**MODIFICATION REQUEST:
Cobaki Estate Residential Community
Development
Cobaki Lakes, Tweed Heads**

**08_0200 MOD 2 – Winning of Fill from
Precincts 9 and 11 to be utilised in the
Central Open Space area**

Director-General's
Environmental Assessment Report
Section 75W of the
Environmental Planning and Assessment Act 1979

April 2014

PRECINCT 9 BORROW AREA EARTHWORKS PLAN					
TASK	BY	INITIAL	DATE	APPROVED	RPEQ No 7817
REVIEW	CS		11.12.13	DRAWING NUMBER	REVISION
DESIGN	CJE		11.12.13	YC0229-1E1-EW13	A
DRAWN	GS		11.12.13

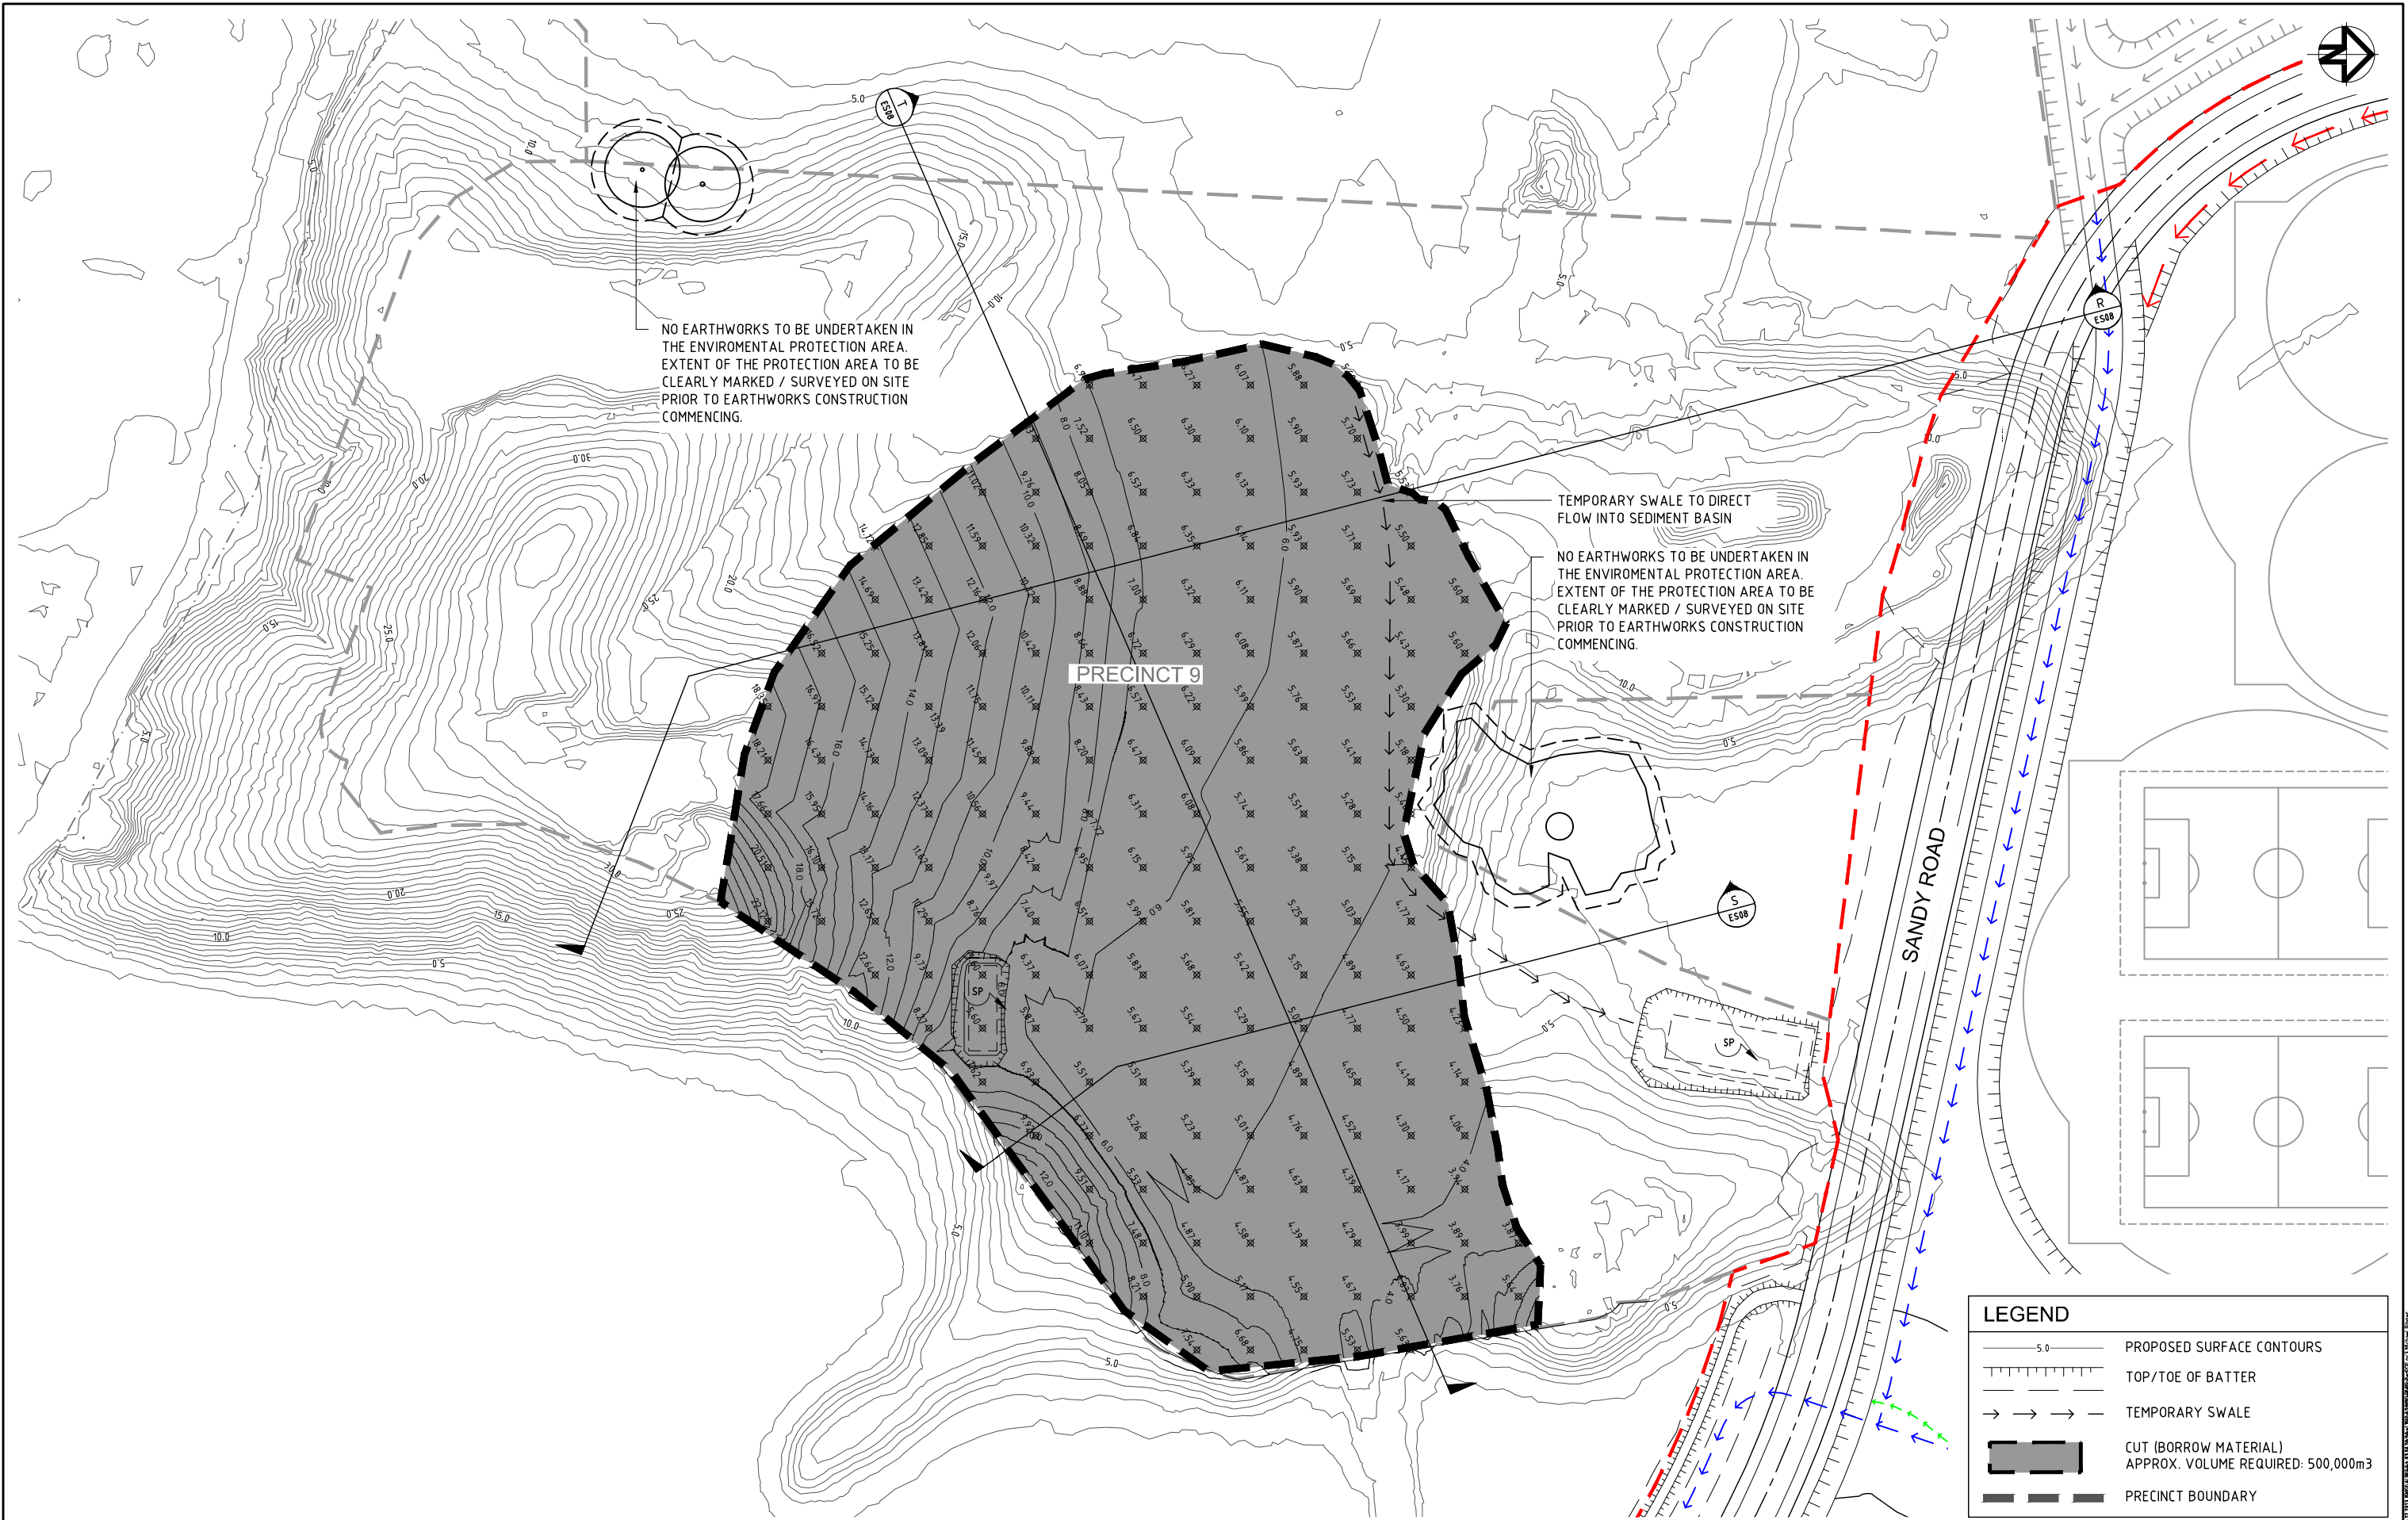
- there is a lack of detail regarding the amount of fill to be placed in the COS area, and any approval should be restricted to the minimum extent required to achieve the required cut volume;

- a buffer should be applied to the existing Raptor nest on the site;
- council's interpretation of the conditions of approval is that blasting activities are not endorsed. If it is determined that rock blasting is permitted, a copy of any approved blasting plan is requested for council records; and

Council also made note of a former Raptor nest located in the vicinity of Precinct 9 and requested a 100m buffer to the nesting site be applied. The EAR made note of a pair of Wedge-tailed eagles identified nesting in a tree stag on the boundary of Precinct 9 in the 2011 breeding season. However, the fauna baseline study carried out by SMEC for the EAR found that the nest is no longer in existence. Nonetheless, to address council's concerns, the agency recommends the insertion of new Condition 38B which requires the proponent's Environmental Officer to determine whether the existing nesting site is currently in use by any Raptor species. If so, no works within a 100m radius of the nesting site will be permitted to occur. In addition, new Condition 39A requires the establishment of a 5m buffer in the form of high visibility netting/fencing to preserve the former nesting tree should the species wish to return during future breeding seasons.
